Application Ref:	3/2021/0191	 Ribble Valley Borough Council www.ribblevalley.gov.uk
Date Inspected:	03/05/2021	
Officer:	RB	
DELEGATED ITEM FILE REPORT:		APPROVAL

Development Description:	Construction of two storey side extension and single storey extension to rear.
Site Address/Location:	5 Milbeck Close, Longridge, PR3 3LQ

Proposed Side Elevation

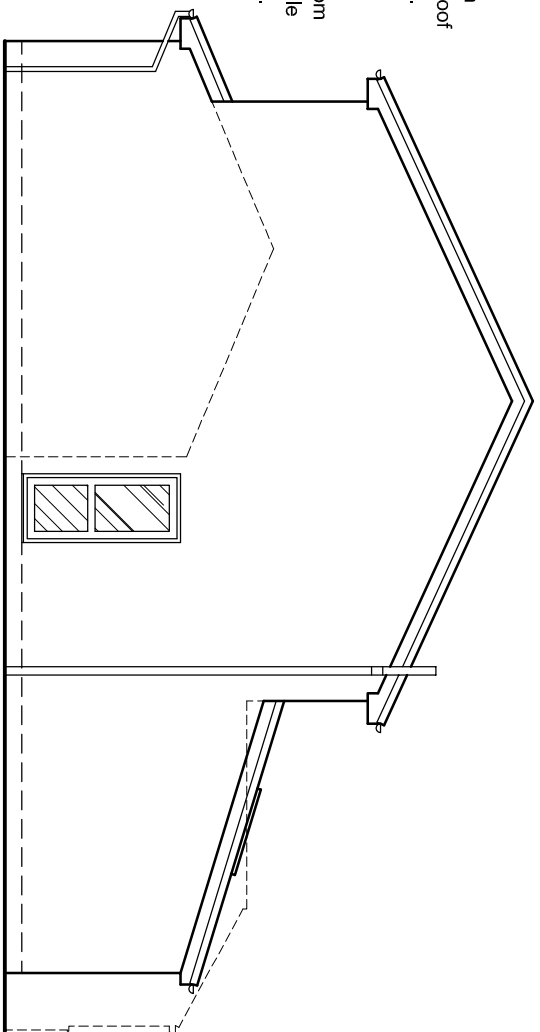
The application site is a detached two storey property that benefits from an attached garage. The proposed two storey extension has a sideward projection of 2.5m and will be situated above/behind the existing garage. The ridge of the extension will be set down from the ridge of the house by 200mm. The extension is to be constructed in materials to match the main dwelling. Therefore, it is considered that the proposed side extension will remain subservient to the main dwelling and will have minimal impact on the visual amenity of the area.

Notwithstanding the above, the distance of 10 metres between the rear elevation of 6 Milbeck Close and the blank gable elevation of the proposed two-storey side extension would fall short of the recommended separation distance of 12-14 metres. As such, I consider that there would a loss of outlook from the rear habitable room windows of no.6 Milbeck Close and the proposed extension would have an overbearing impact due to its size, scale and proximity to the rear garden boundary of this neighbouring property.

Proposed Site Plan 1:200

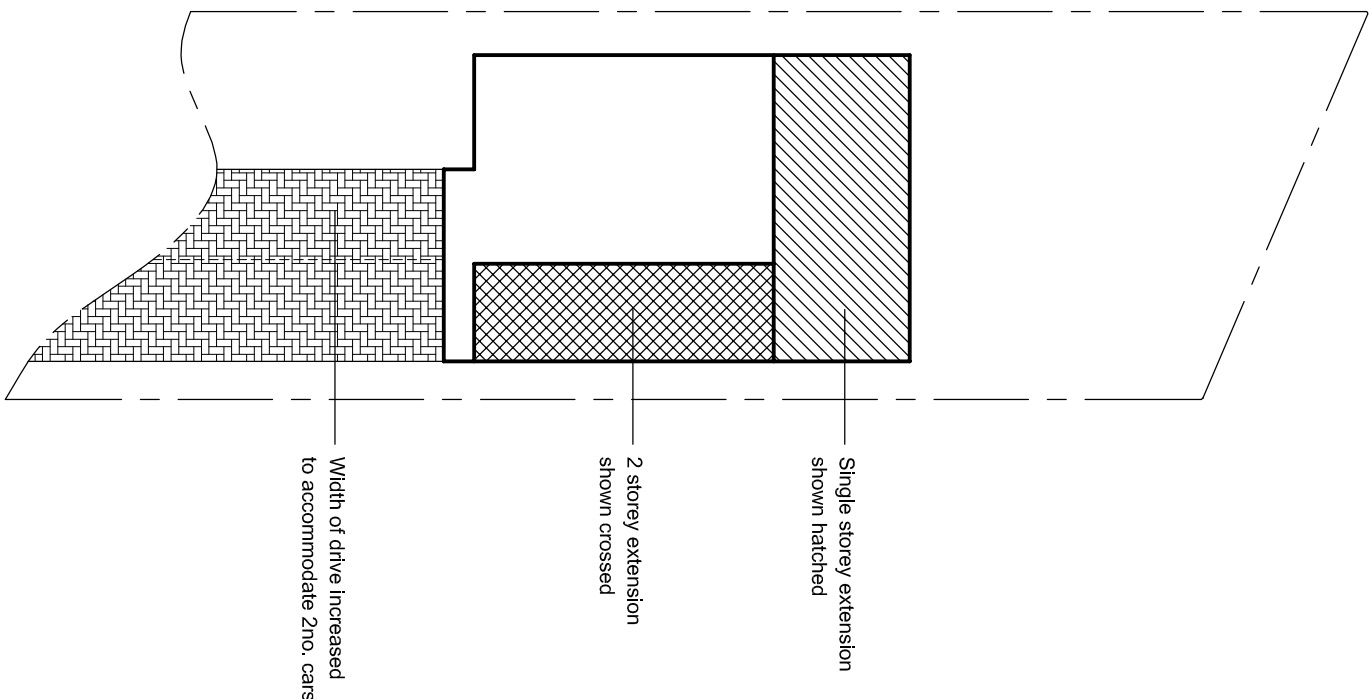
1. The proposed development, by virtue of its scale, mass and proximity to the neighbouring property, would result in an unacceptable loss of outlook from the rear windows of 6 Milbeck Close and would have an overbearing impact that would affect the ability of the occupants of 6 Milbeck Close to enjoy their garden.
